Reference: Westpointe 10MW Data Center

This provides a response to review comments received April 17, 2024, from the Albuquerque Development Facilitation Team on the proposed Westpointe 10MW Data Center located at Daytona Rd NW between 94th St NW and 90th St NW.

Application For: SI-2024-00451 – SITE PLAN DFT

PROJECT NO.: 193806697  
DWN BY: HKK    CHKD BY: JRA    APPD BY: CMR  
ISSUE DATE: 08/01/2024  
ISSUE NO.: 5  
SHEET TITLE: SITE PLAN  
SHEET NO.: C-101

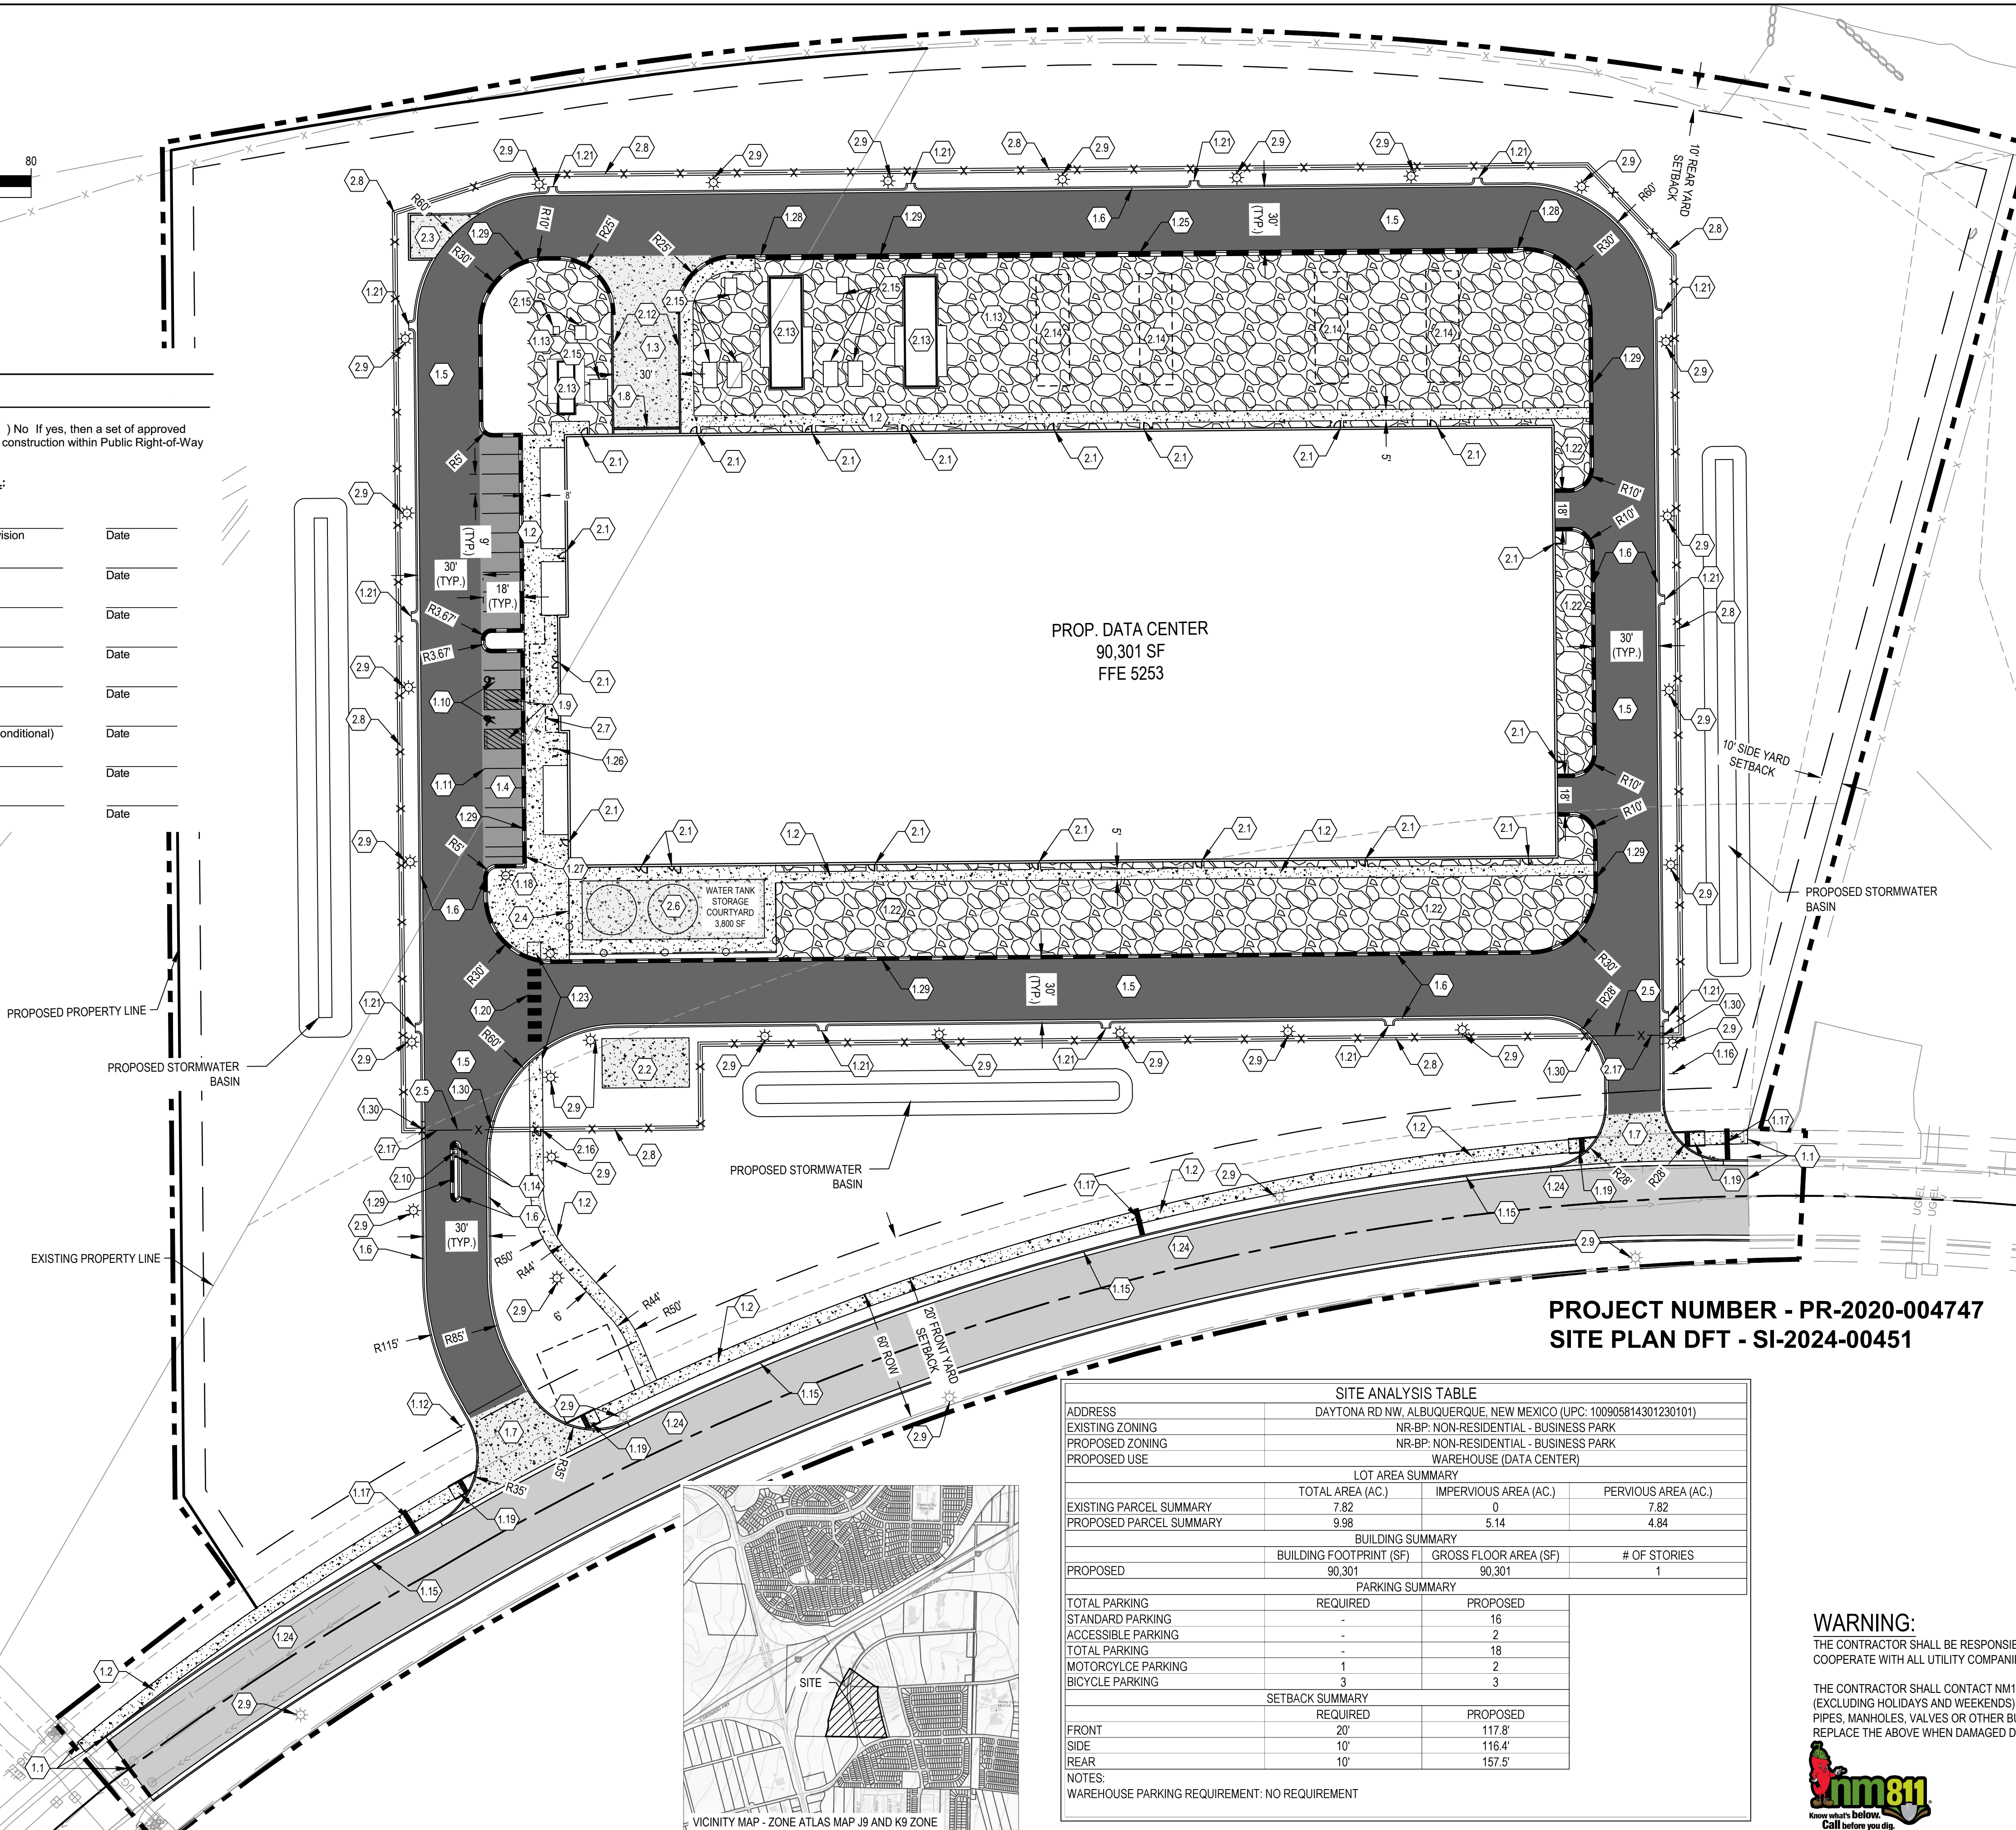
- a. Please update to include the water meter and provide any water meter sizing calculations that have been completed. This needs to include peak demand and a maximum continuous demand.**

- b. If a large meter is required, a 35'x35' easement will be required for the meter.**

- c. Please configure the domestic service to have a separate line than the proposed fire protection line.**

- d. The fire protection line can be an unmetered line and must be separated from the domestic service as presented on the current utility exhibit.**

The MEP design is being currently being finalized with site specific design information. Once available, the design team will coordinate with ABCWUA and update the plans accordingly.

The utility plan has been updated to show proposed separate domestic and fire service line with meter location, easement, and RPBA's accordingly.

Acknowledged. The utility plan has been updated to show a separate domestic and fire service line.

Acknowledged. The utility plan has been updated to show a separate domestic and fire service line.
